Consultation Response from KC, Highways Development Management**2022/91283 Waverley United Reformed Church, Waverley Road, Huddersfield, HD1 5NA****Change of use of former church building (Class F1f) into soft play facility with ancillary cafe (Class E) [within a Conservation Area]****Date Responded: 25/07/22****Responding Officer: J Turner****Responding Ref: K5-5SE/36**

This application seeks approval for the change of use of former church building (Class F1f) into soft play facility with ancillary cafe (Class E) [within a Conservation Area] at Waverley United Reformed Church, Waverley Road, Huddersfield.

Formerly Waverley United Reformed Church, Waverley Road, Huddersfield, Kirklees, HD1 5NA

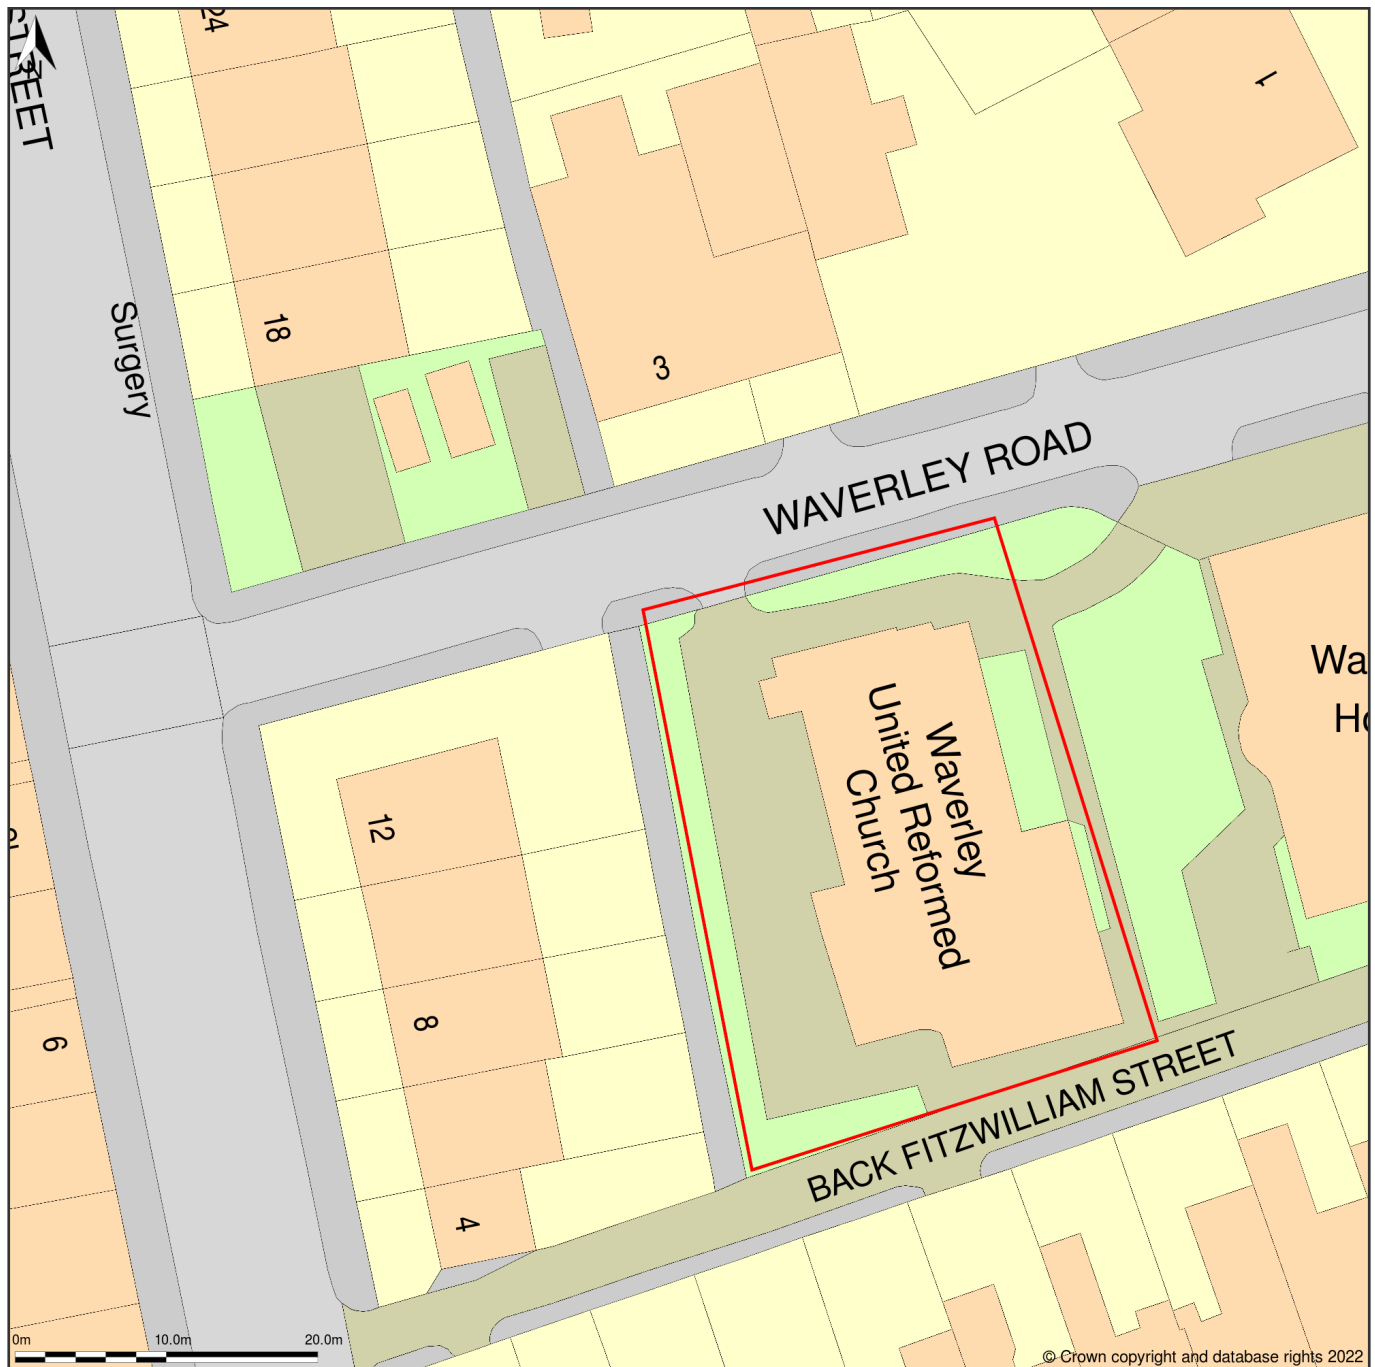
Whilst no external works are to be carried out, it would seem likely that the change of use would generate more traffic by way of deliveries and servicing and may also create a greater requirement for refuse capacity.

As such, whilst the previous use is taken into account, as is the proximity to the town centre, Highways DM would still ask for the off-street parking and access provision plus bin storage and collection points to be shown on a plan. Highways DM has no concerns regarding parking numbers as it is apparent that there are pay and display car parks within easy walking distance of the building, but the on-site provision should still be shown, including any spaces designated for disabled drivers.
